Timothy Short Plat
File Number SP-08-00018
FINDINGS OF FACT, DECISION AND CONDITIONS OF APPROVAL

Requested Action: Andrew & Michell Schmidt, landowners, submitted a preliminary short plat application on April 24, 2008 to subdivide approximately 12.04 acres into four (4) 3.01-acre parcels. The subject property was zoned Agricultural 3 at the time of application within a Rural Land Use designation.

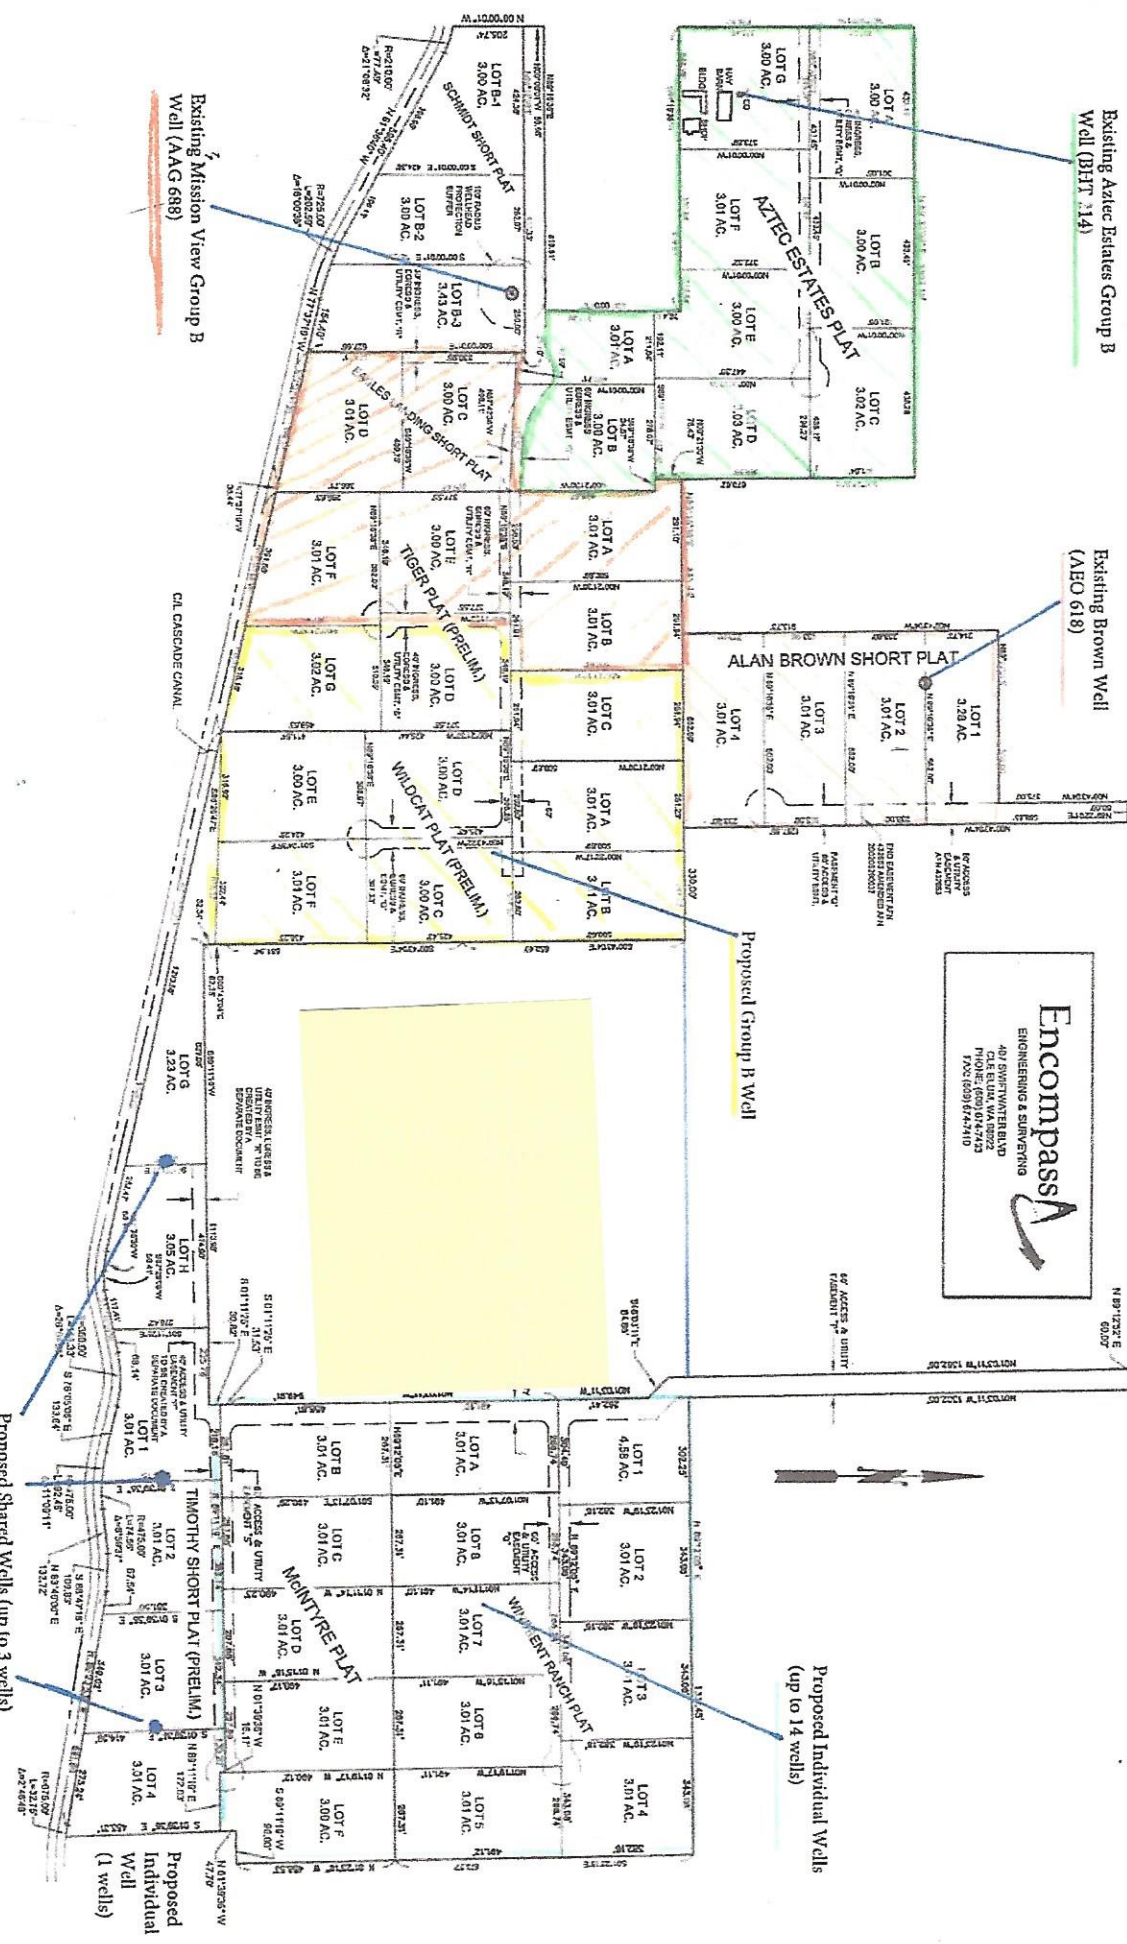
Kittitas County Public Health commented that the proposed shared wells need to be moved so they are at least 50 feet from all property lines and that all individual and shared wells must have approved individual well site review applications submitted and approved in addition to a signed, notarized and files shared well users agreement. They also provided comments regarding on-site septic system standards and that soil logs would need to be completed.

Applicant Response: "All domestic water is mitigated and we are in the process of evaluating the most efficient use most likely to be Class B wells on these plats. We will be submitting a Class B well site inspection application sometime in late November or Early December. We will drill all the required wells this winter. Our desire is to drill the wells and Bond around all of the well site improvements as it might be some years before development would occur. This property is an active farm so the less obstructions the better until time of development."

Staff Response: Kittitas County Community Health Department requirements will be addressed prior to final approval.

TIMOTHY SHORT PLAT
A PTN. OF SEC. 32, T. 18N, R. 19E, W.M.
KITITAS COUNTY, WASHINGTON

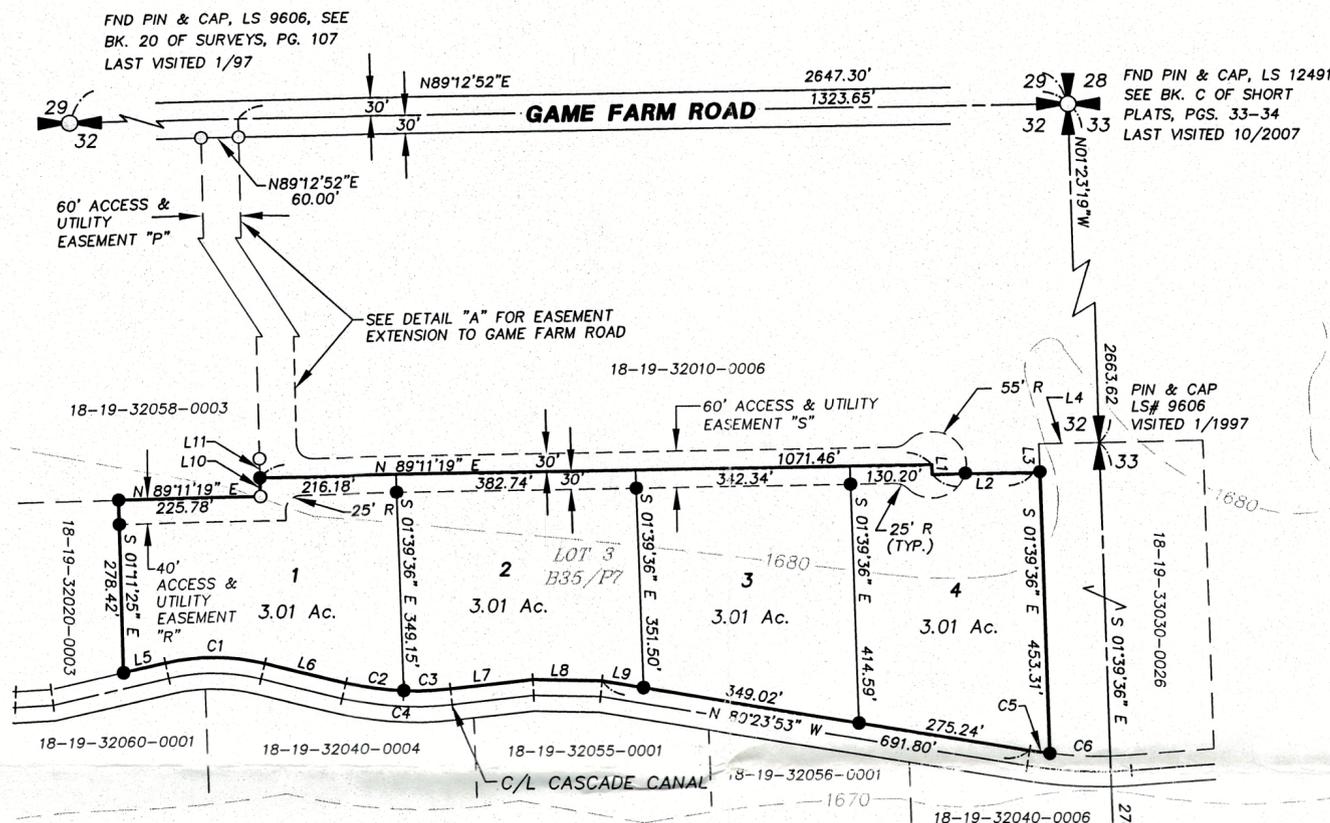
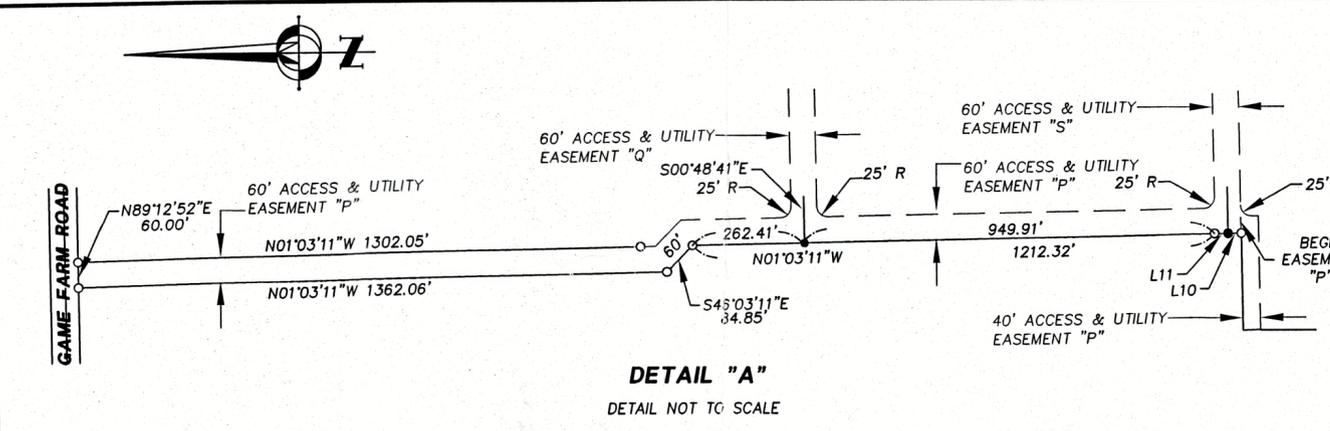
- A. The plat shall have the following updates prior to final approval:
 - 1. For the 60' access easement, please reference AFN 200710220075, 201010050029 and 201010050030.
 - 2. The plat will need to be stamped and signed by a surveyor actively licensed in the State of Washington.
 - 3. Adjacent property owners list shall be updated
- B. Taxes must be paid in full on all tax parcels involved in this land use action as required by Washington State Law (RCWs 84.40.042 & 84.56.345) prior to final plat recording.
- C. This preliminary approval will expire 5 years from the date of this determination if no extension is filed in accordance with KCC 16.32.090.
